October 18, 2016

Re: Winnelson Wake House Remodel Addition
3545 Princeton Dr NE
Traffic Circulation Layout
Architect's Stamp 09-26-16 (G16D152)

TCL PLAN

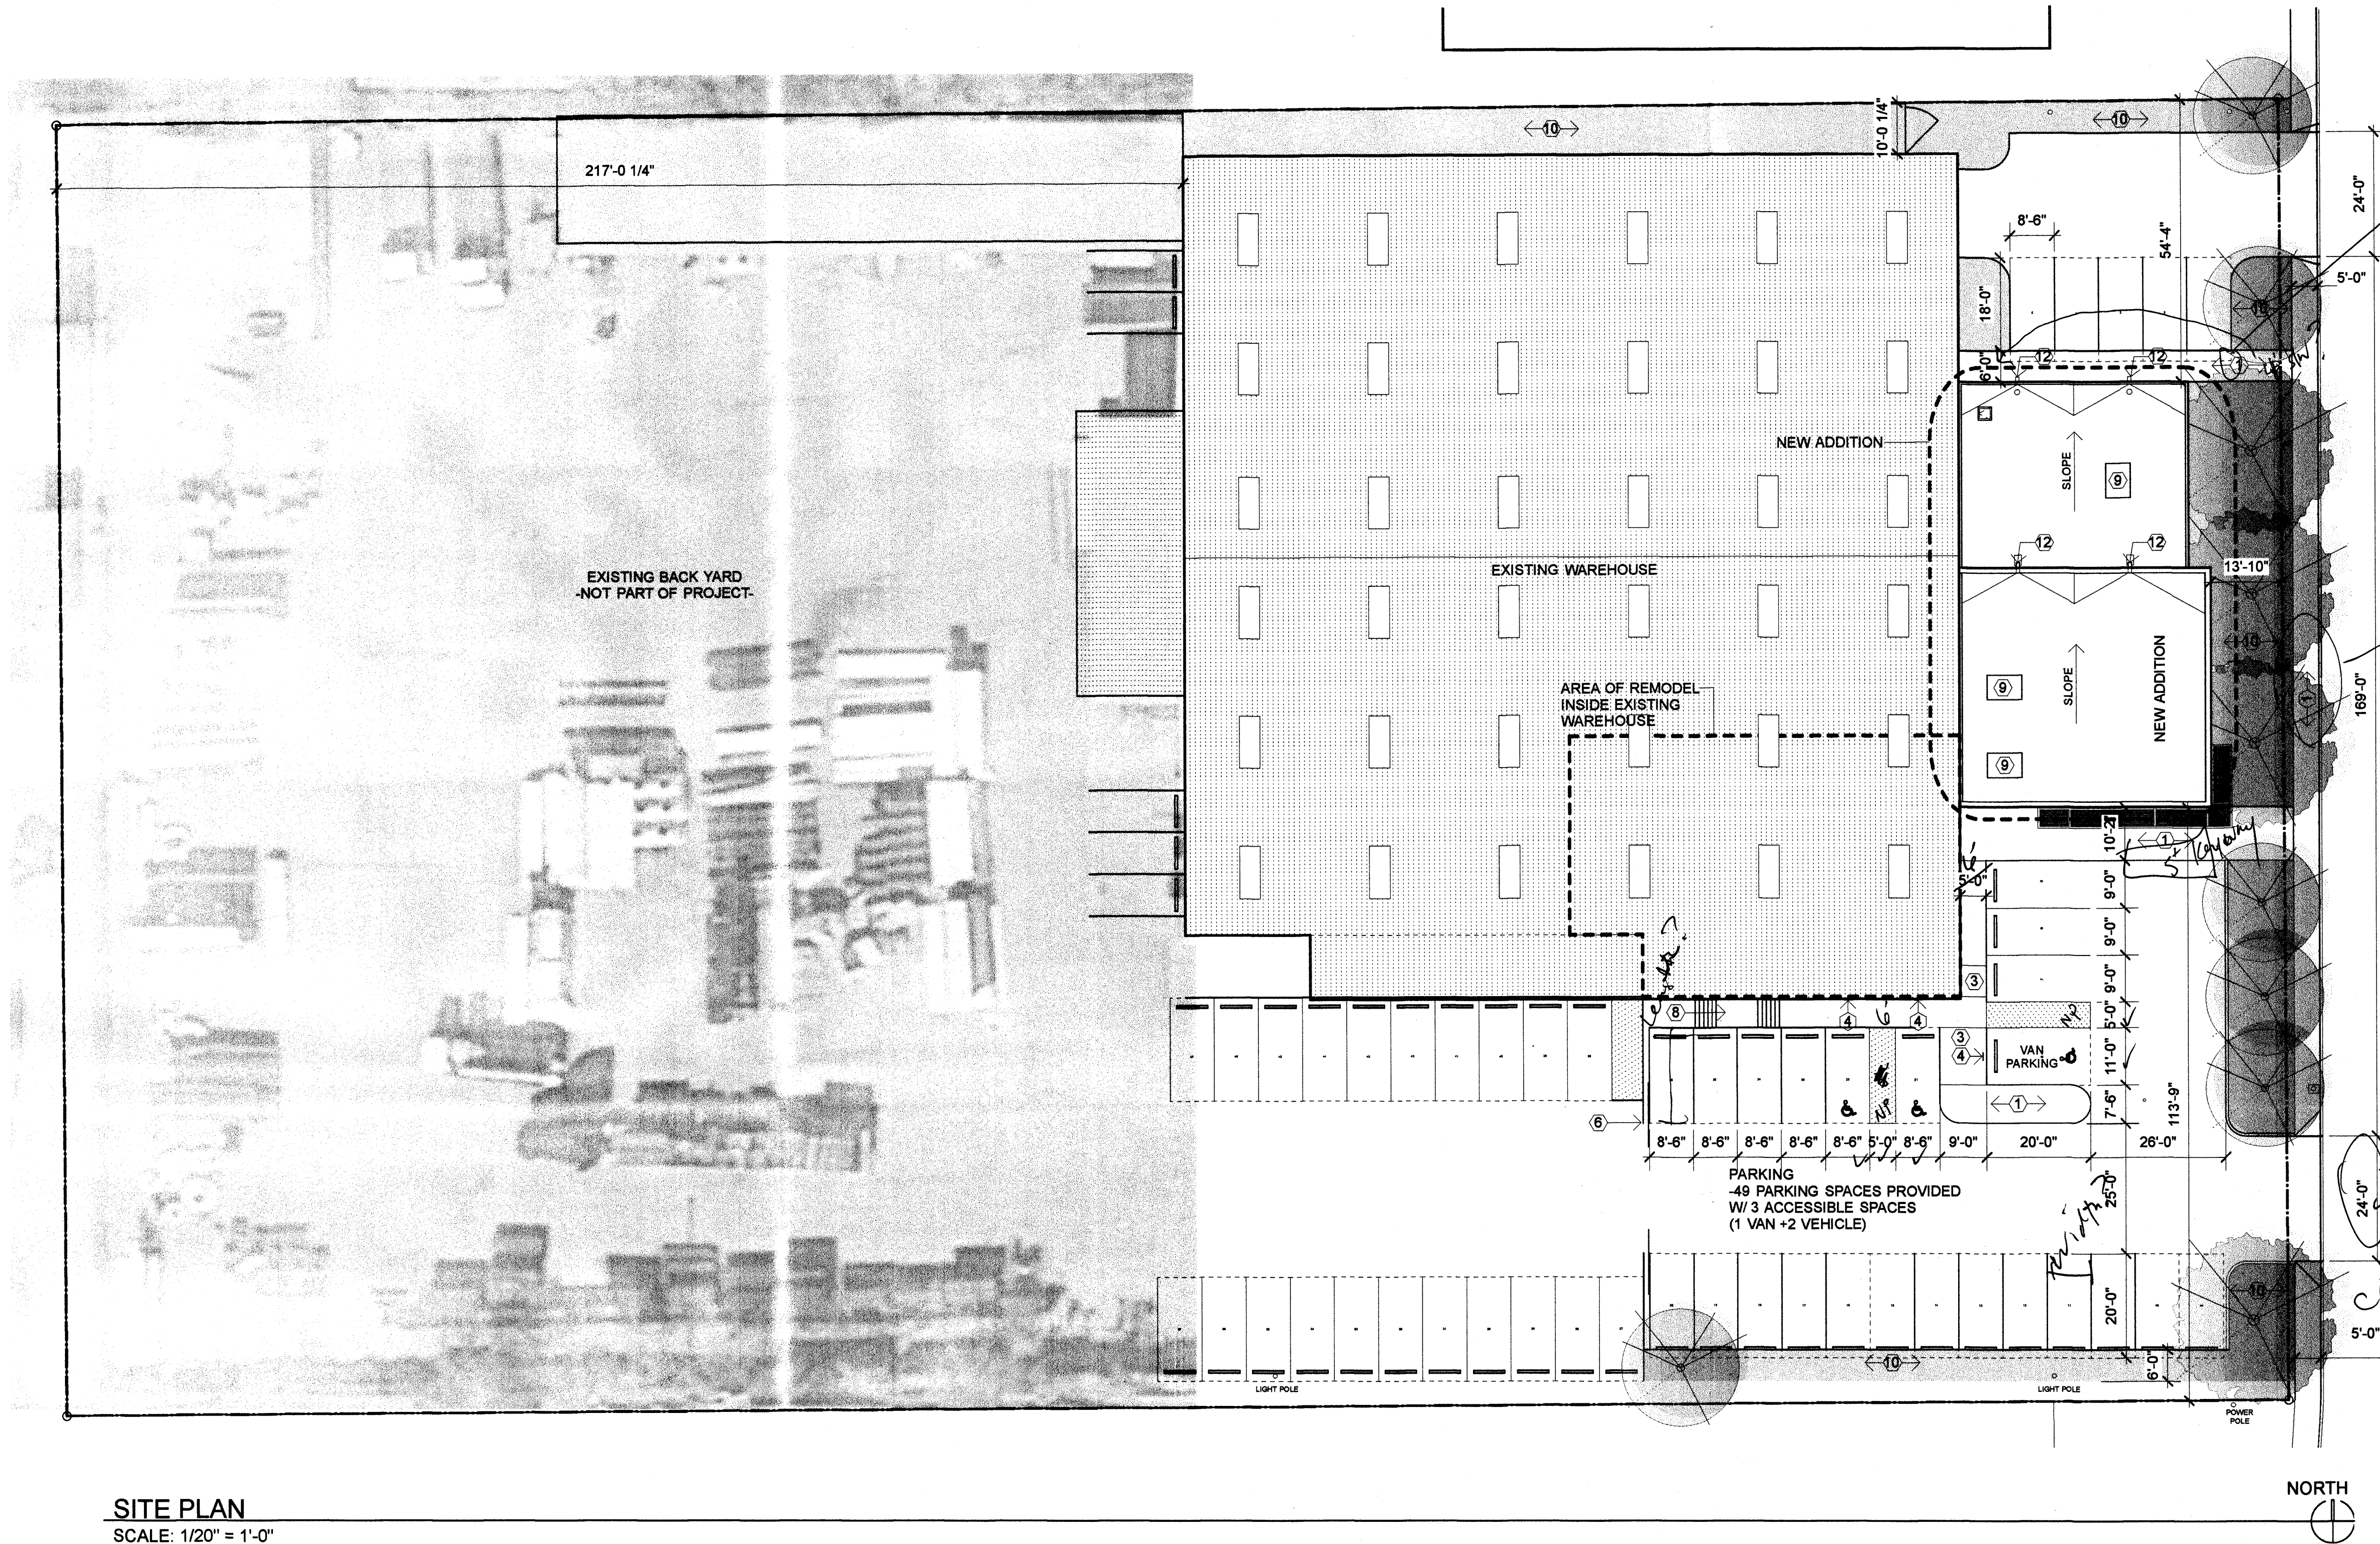
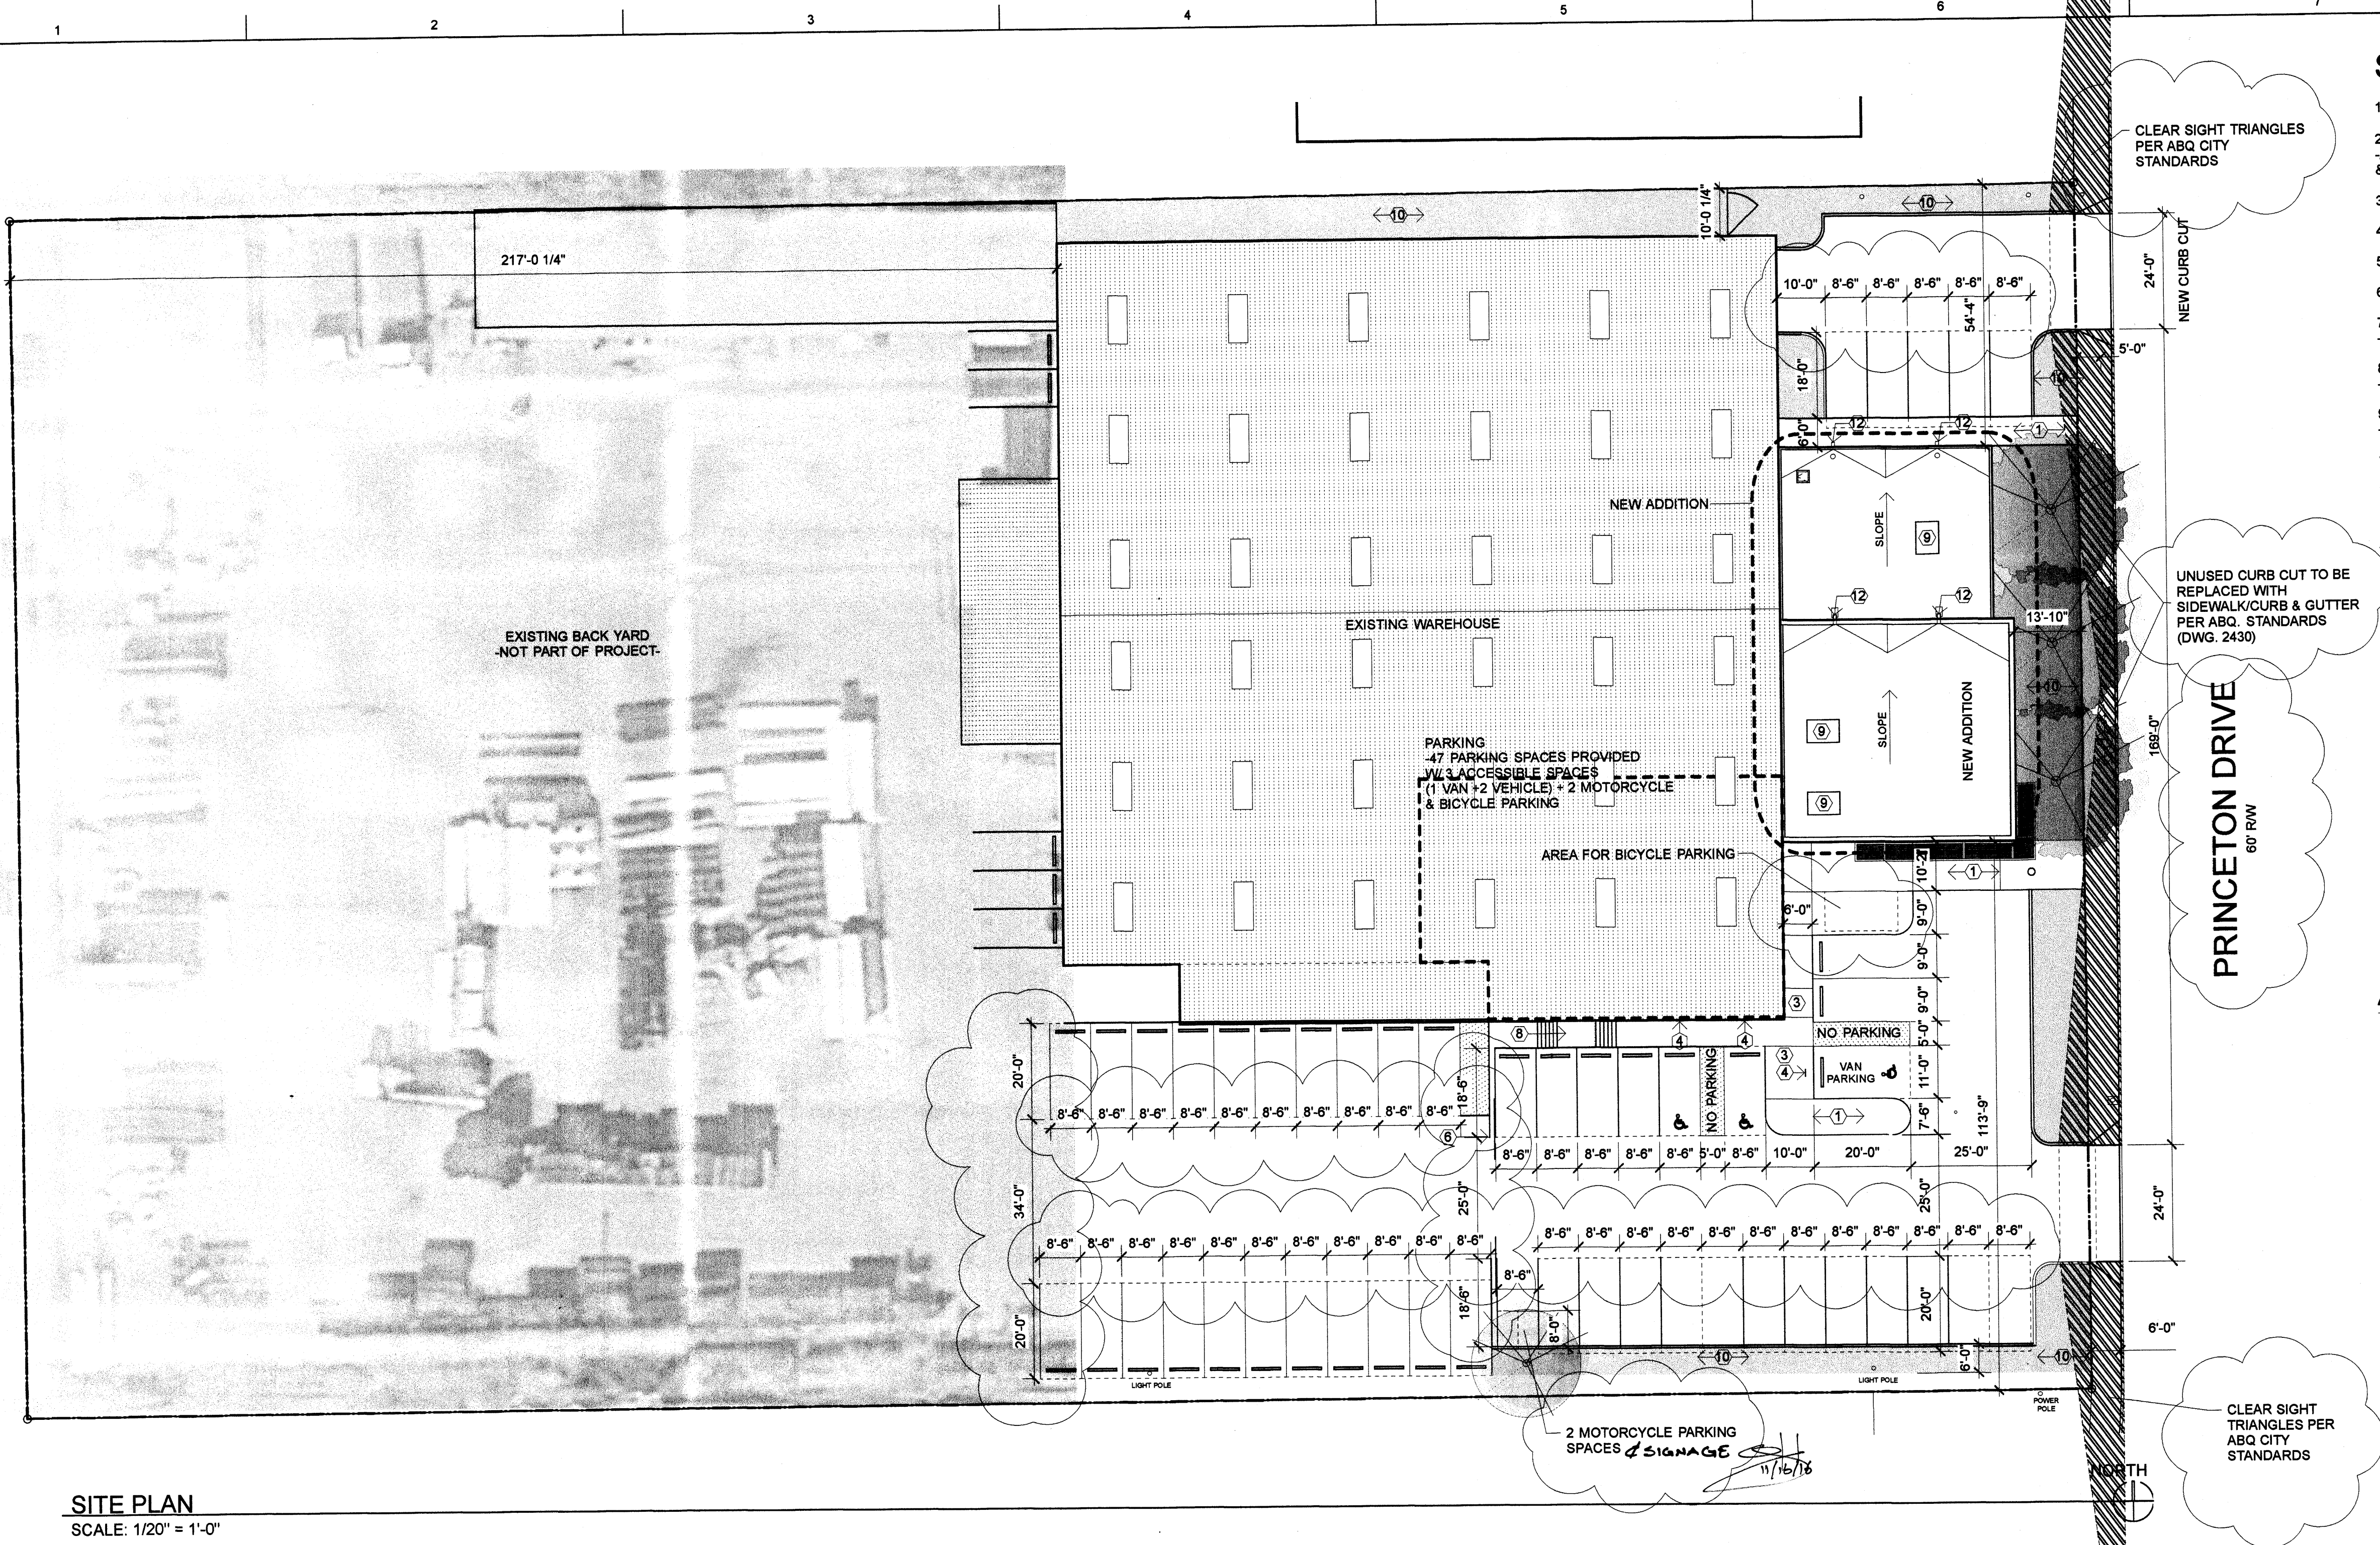
1. Identify the right of way width and label on Princeton Dr NE.
2. Please list the width and length for all existing and proposed parking spaces. Some dimensions are not shown.

3. The ADA access aisles shall have the words **"NO PARKING"** in capital letters, each of which shall be at least one foot high and at least two inches wide, placed at the rear of the parking space so as to be close to where an adjacent vehicle's rear tire would be placed. (66-1-4.1.B NMSA 1978)

4. A 5 ft. keyway is required for dead-end parking aisles.
5. Per DPM, a 6 ft. wide ADA accessible pedestrian pathway is required from the HC parking stall access aisles to the building entrances. Please clearly show this pathway and provide details.

6. Call out where motorcycle parking and bicycle parking is located on site plan.
7. All sidewalks along streets should be placed at the property line.
8. Show the clear sight triangle and add the following note to the plan:
"Landscaping and signage will not interfere with clear sight requirements. Therefore, signs, walls, trees, and shrubbery between 3 and 8 feet tall (as measured from the gutter pan) will not be acceptable in the clear sight triangle.

9. Unused curb cuts must be replaced with sidewalk and curb & gutter. A build note must be provided referring to the appropriate City Standard drawing.

10. Please specify the City Standard Drawing Number when applicable.
11. Please include two copies of the traffic circulation layout at the next submittal.
